From: Deputy Clerk [REDACTED]
Sent: 03 February 2020
To: Amber Willard
Cc: Clerk
Subject: Application BE/149/20/PL - 339 Chichester Road, Bersted

SITE PLAN

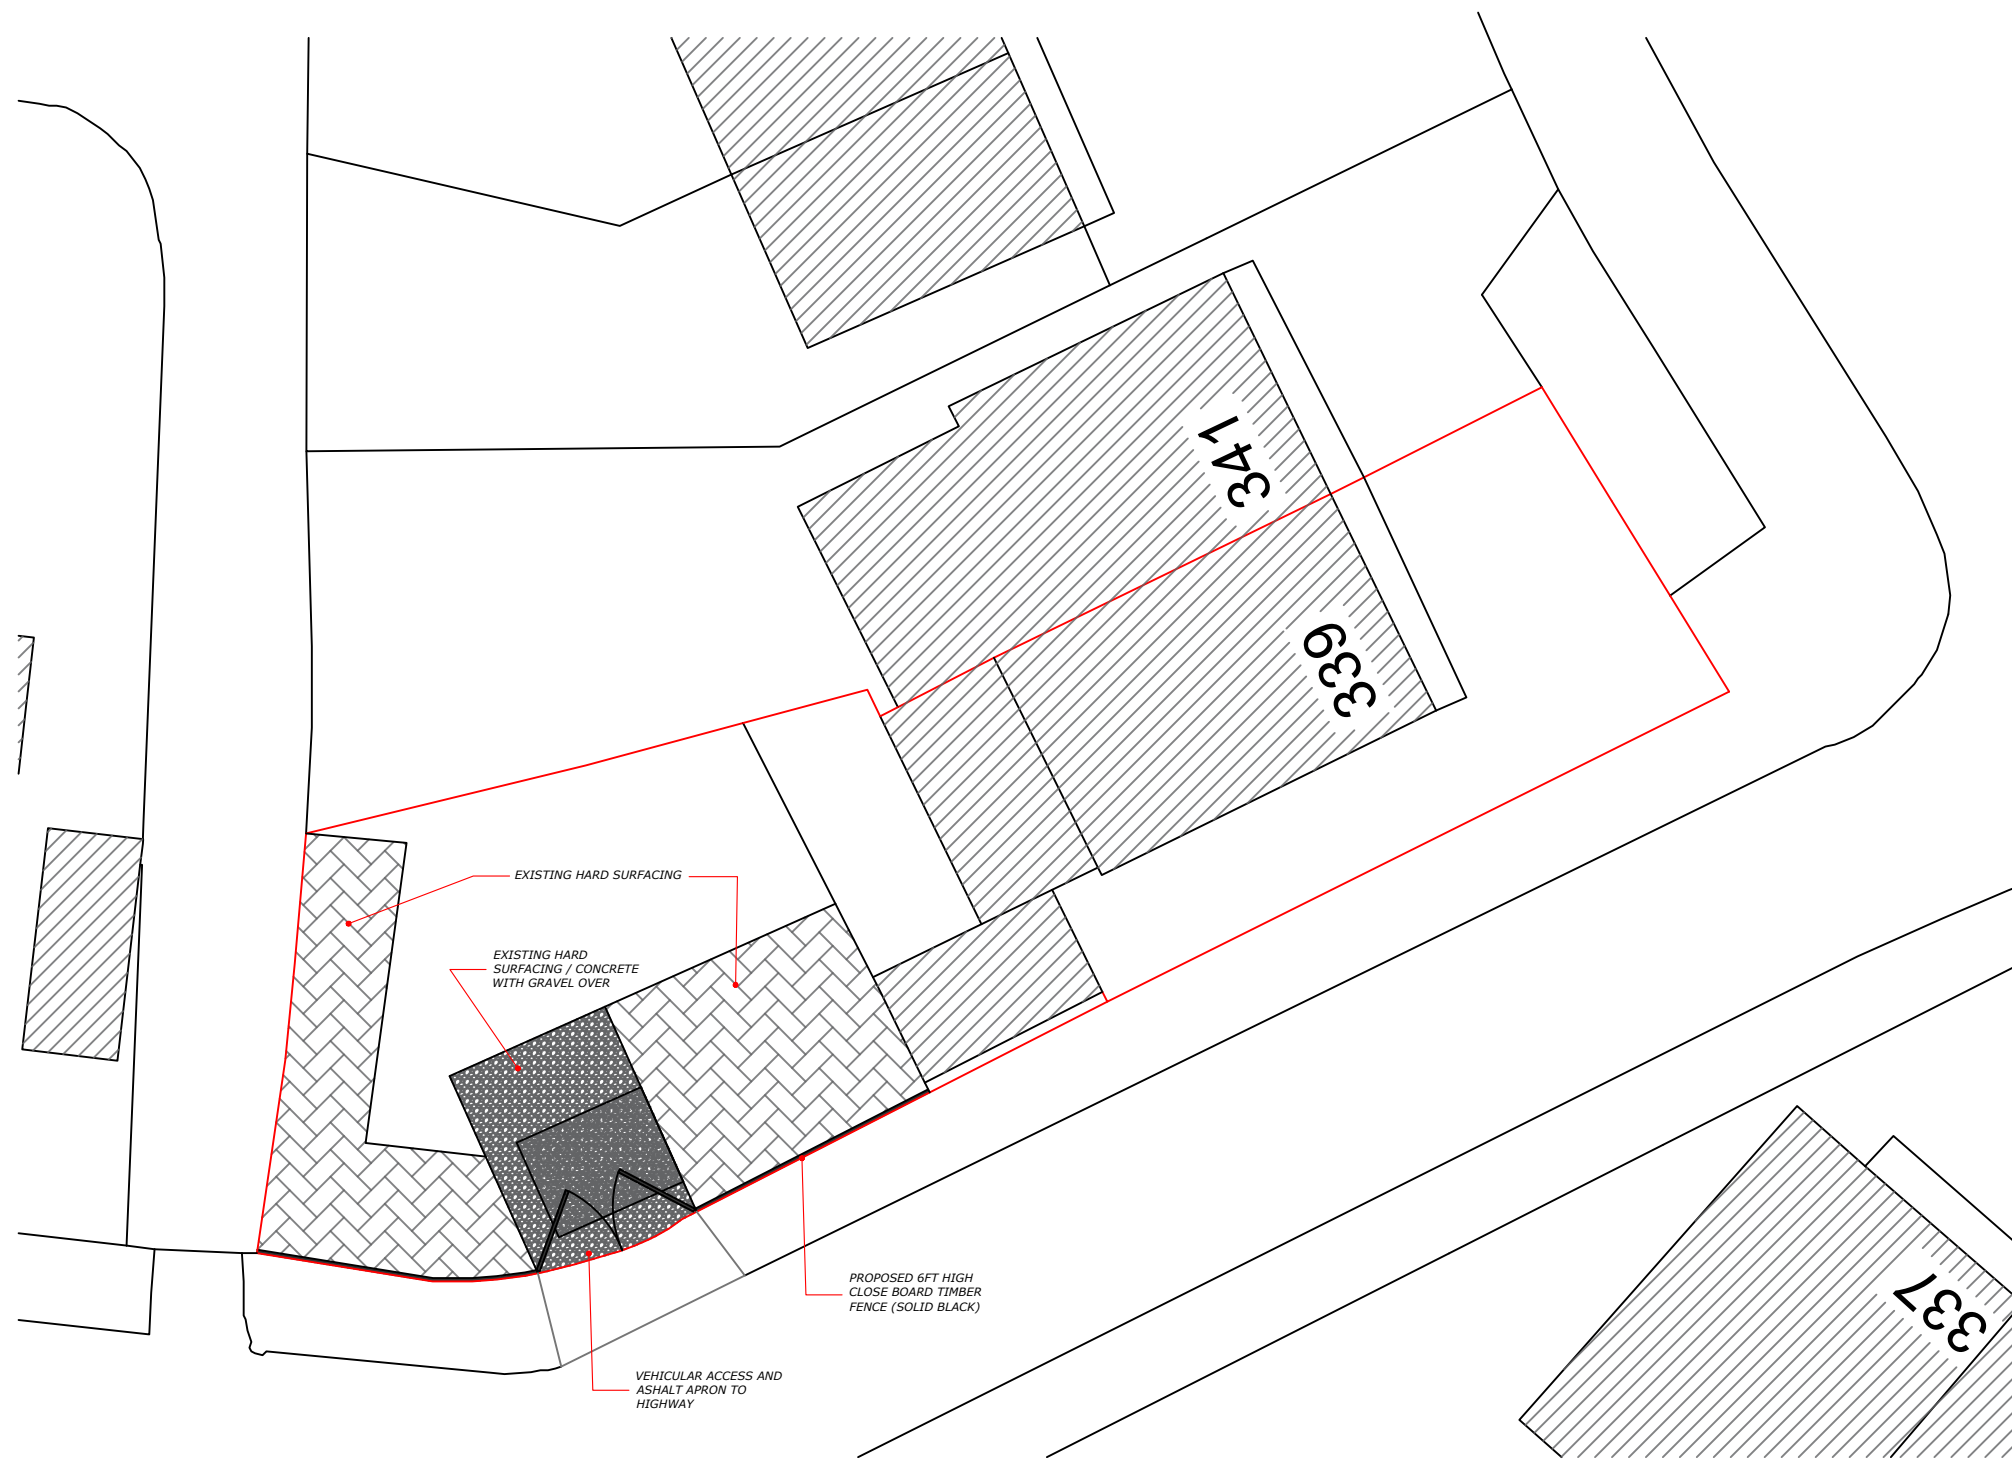
The Planning Committee are reserving comment on this application until the applicant has demonstrated visibility for the vehicular access as requested by WSCC Highways. Could you let me know when this is likely to be lodged, so that the committee can comment once known and WSCC highways have reviewed it.
